Our Case Number: ABP-316051-23

Re: Renewable energy development comprising 9 no. wind turbines and associated infrastructure.
Umma More and adjacent townlands, County Westmeath.

CASE Reference: 316051
Ummamore Renewable Energy Development (Ummamore Wind Farm)

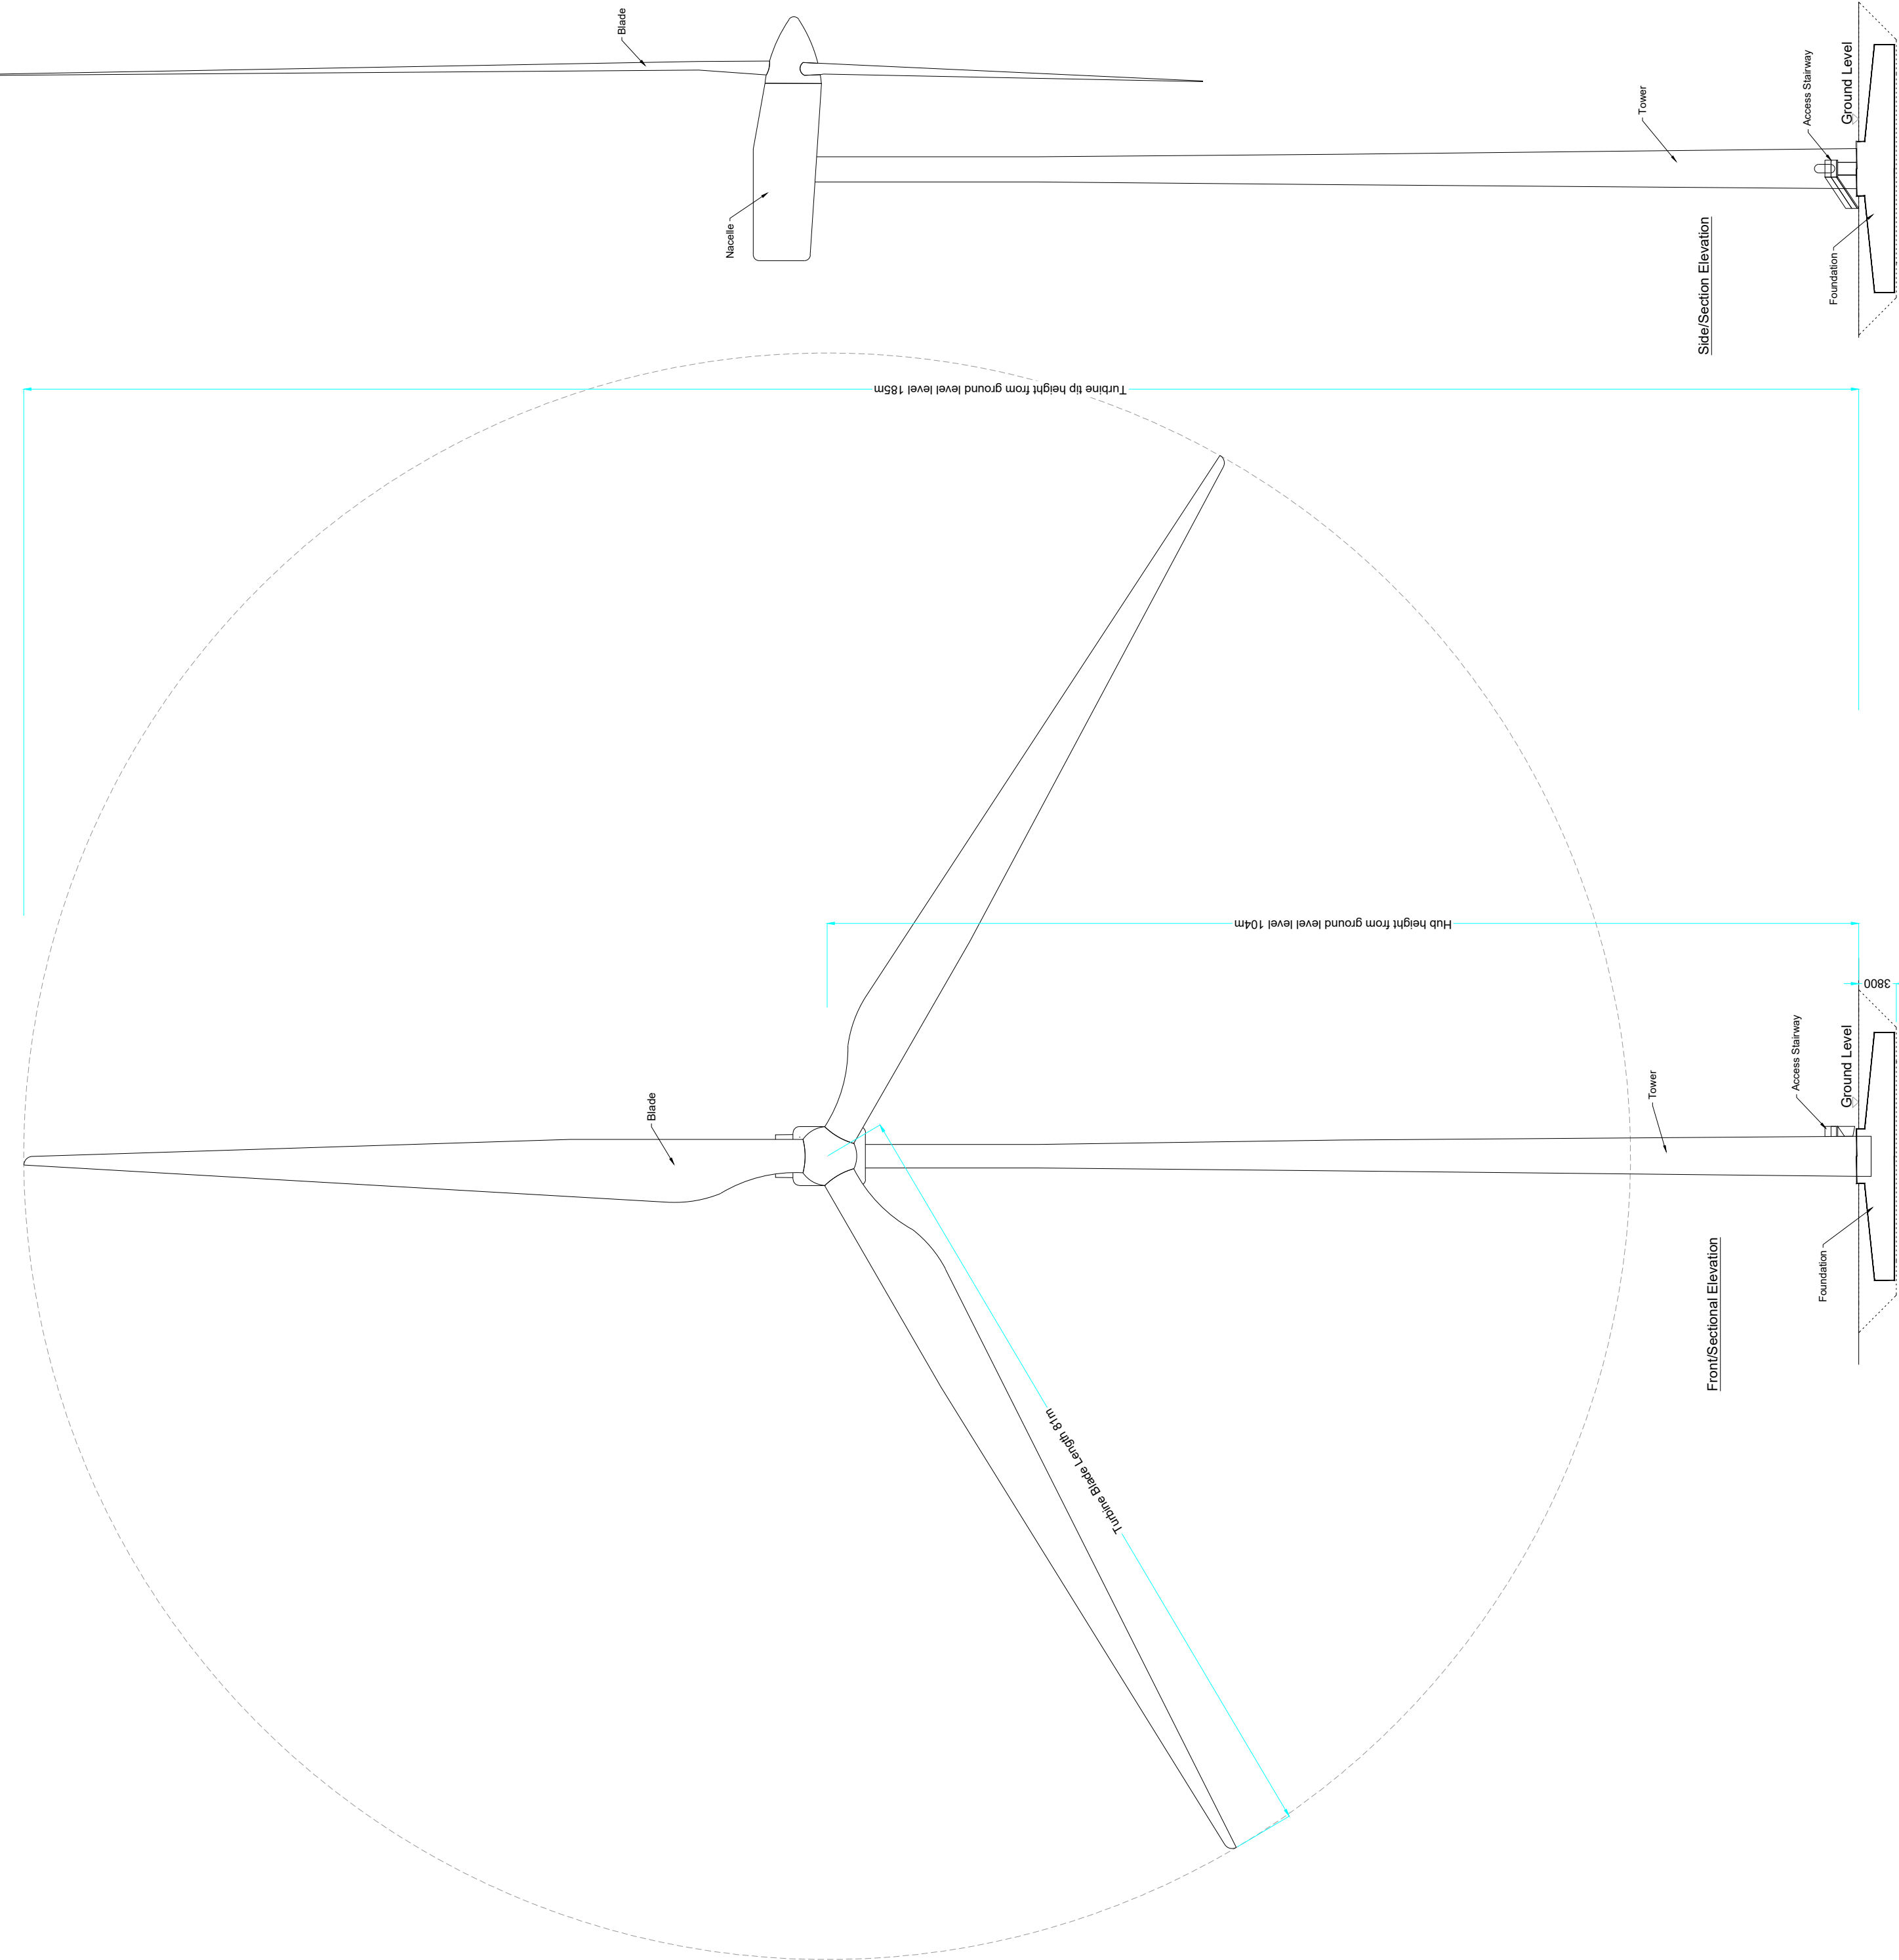
AT 185m, these turbines will totally dominate the local landscape. This is a rural, scenic area which is known for its wildlife and sense of peace and quiet. The landscape will be severely damaged by industrial structures which will be among the biggest in Ireland and more suited to an offshore location. They are simply too tall to be situated in Ballymore and Drumraney.

The 2006 guidelines being used for planning of these windfarms are grossly outdated. They are relevant to small domestic lower scale turbines, not the 185m industrial size ones planned for the proposed Ummamore wind farm. The current Irish Planning guidelines for wind farm rely on the UK noise assessment model that dates back to 1996. This model is widely recognised as not fit for purpose in light of the vast increase in turbine size and power.
